ROAD SAFETY AUDIT RESPONSE REPORT

A27 ARUNDEL ROAD / B2132 YAPTON LANE - EXTENSION OF A27 RIGHT TURN LANE

STAGE 1

30 August 2017

T:\Projects\11000 Series Project Numbers\11324\ITB Land North of Walberton\Tech\Acad\I-Transport Drawings\Working Drawings\GA\ITB11324-GA-014 Rev B.dwg

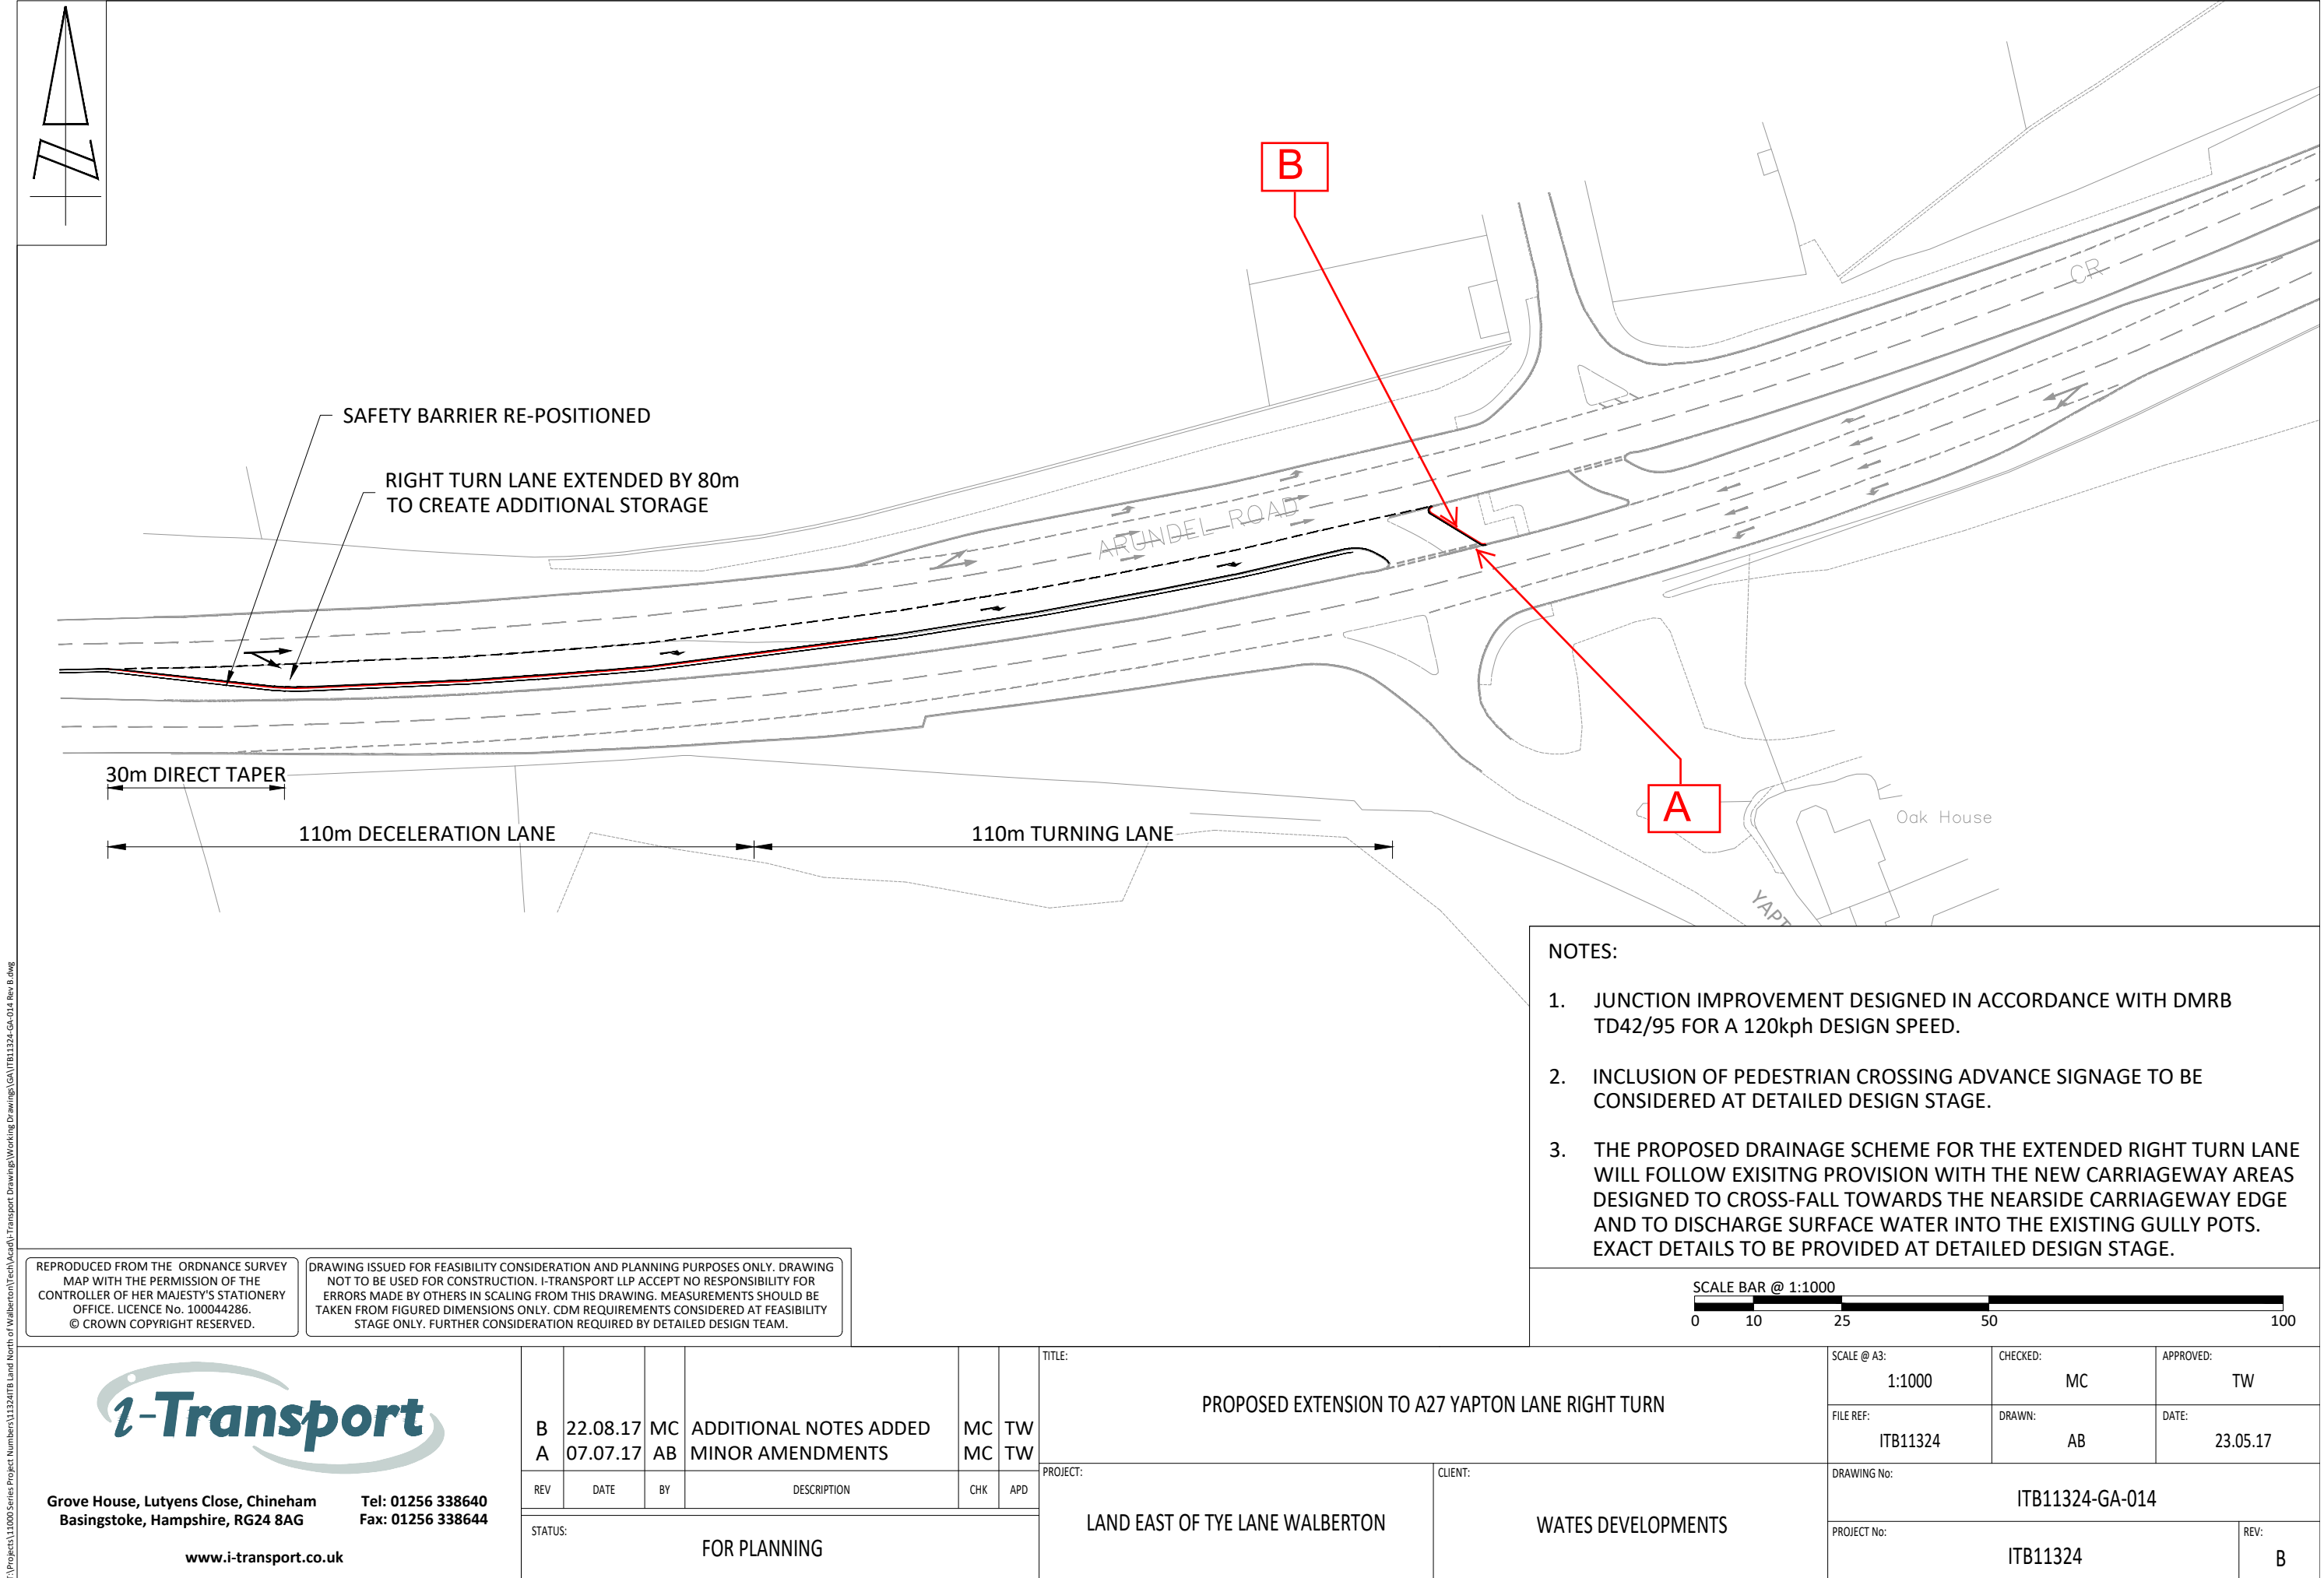
Location: A - A27 eastbound approach to junction.

Summary: Ponding of surface water combined with carriageway profile changes could lead to loss of control accidents.

The kerblines on the centre reservation are being amended as part of these proposals. Consequently, the position of the existing gully on the westbound carriageway may be in an unsuitable position to achieve positive carriageway drainage, leading to possible ponding. Ponding on the carriageway could lead to loss of control accidents in wet or icy conditions.

That horizontal and vertical profiles should be such that water is shed, or that the gully is relocated to prevent ponding.

Location: B – A27 eastbound approach to junction.

Summary: Position and specification of a local direction sign could compromise road safety.

There is an existing local directional sign in the central reservation, indicating destinations and distances for right turning traffic, see figure 1 below, where no details of the relocation or removal of this sign have been provided. Amendments to the central reservation may position this sign in the carriageway running lane. Further, the sign is not passive and is situated at the end of a right turn lane, which is proposed to be extended, where there is potential for greater approach speeds. In the event of a loss of control accident, collision with a non-passive sign could increase the severity of the accident.

That the sign should be repositioned within the verge area of the central reservation and that this sign should be passive.

Agreed – At the Detailed Design Stage a full drainage design will be prepared to ensure that positive drainage of the central turning area is achieved, and any necessary changes to gully positions will be identified and included in the design. It is expected that the gully located on the A27 westbound, which takes water from the central reserve area, will be relocated as part of the proposals. This is indicated on Drawing ITB11320-GA-014 Rev C.

The Stage 2 Road Safety Audit will consider the detail of the drainage design including the location of the westbound gully.

Agreed – The sign will be replaced with a passive sign and relocated into the adjacent verge area. This is indicated on Drawing ITB11320-GA-014 Rev C.
